**CITY OF ALBUQUERQUE  
Planning Department  
March 29, 2006  
DRB Comments**

**PROJECT # 1004766 APPLICATION # 06-00361**

**RE: Gregorio & Rafael Apodaca Addition/p&f**

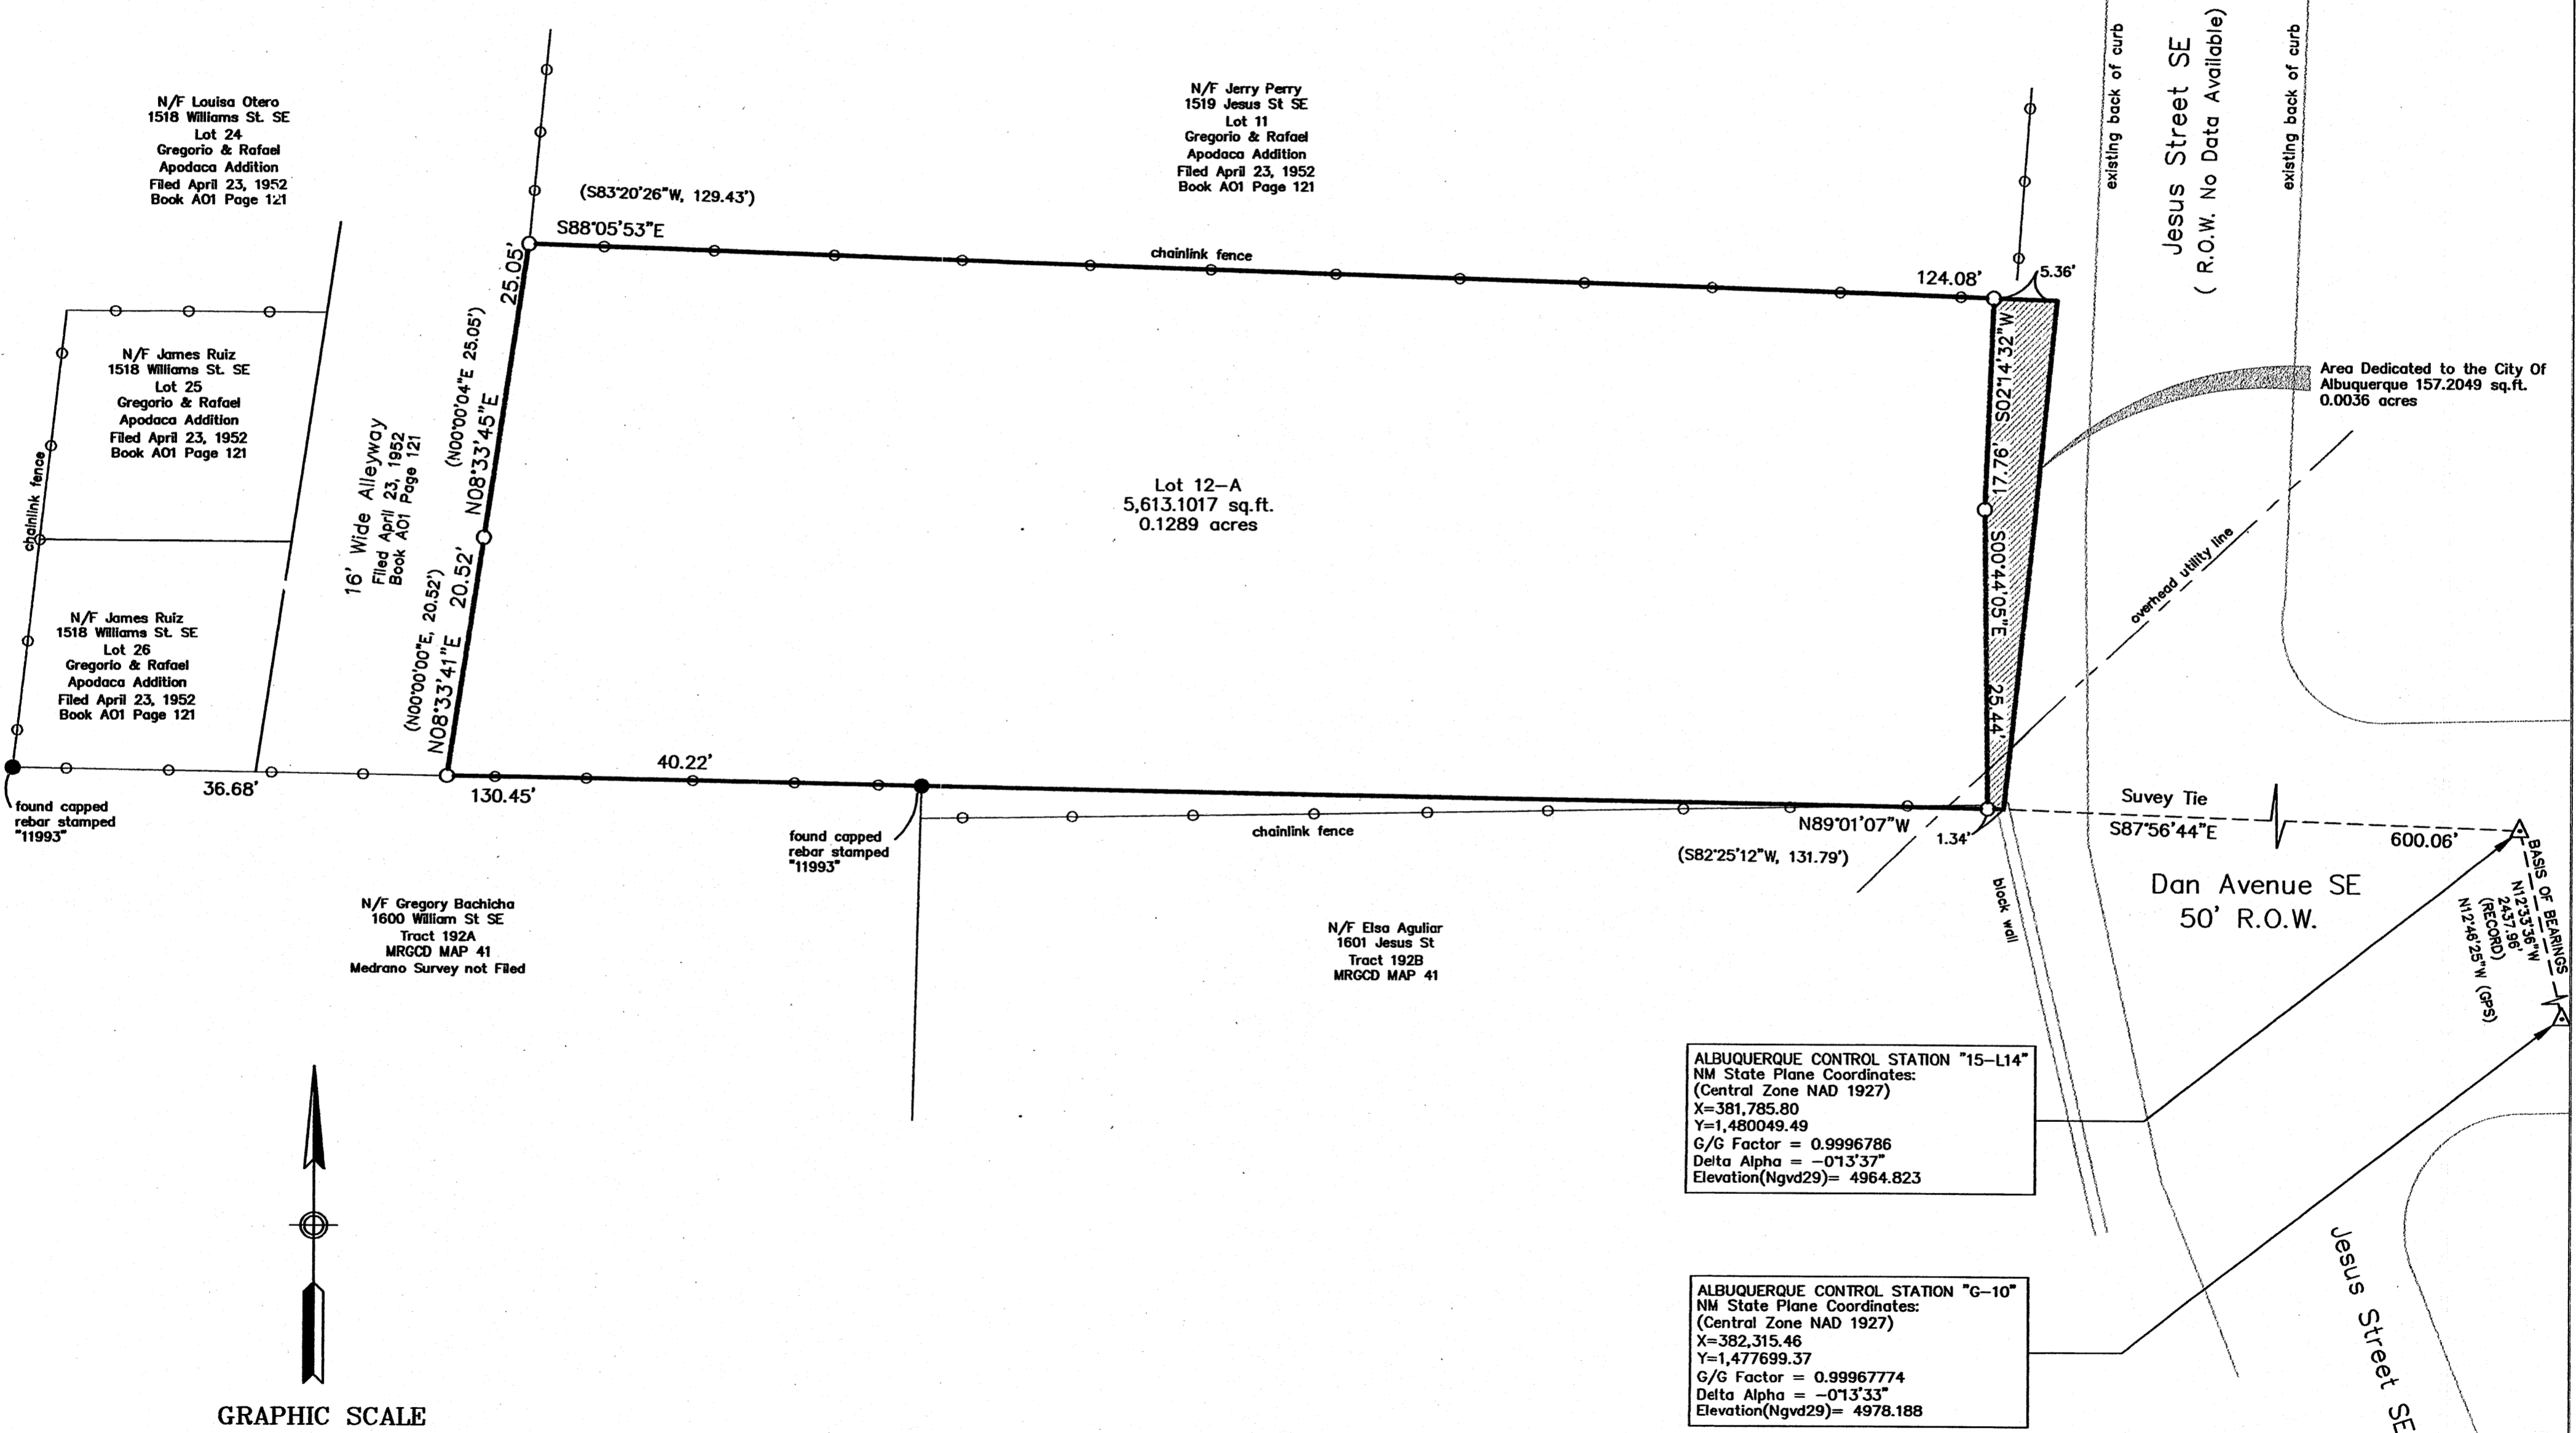
**The lot line which now separates existing Lots 12 & 13 is missing from the replat submittal.**

**What easements are you granting with this replat? They are not shown on the submittal.**
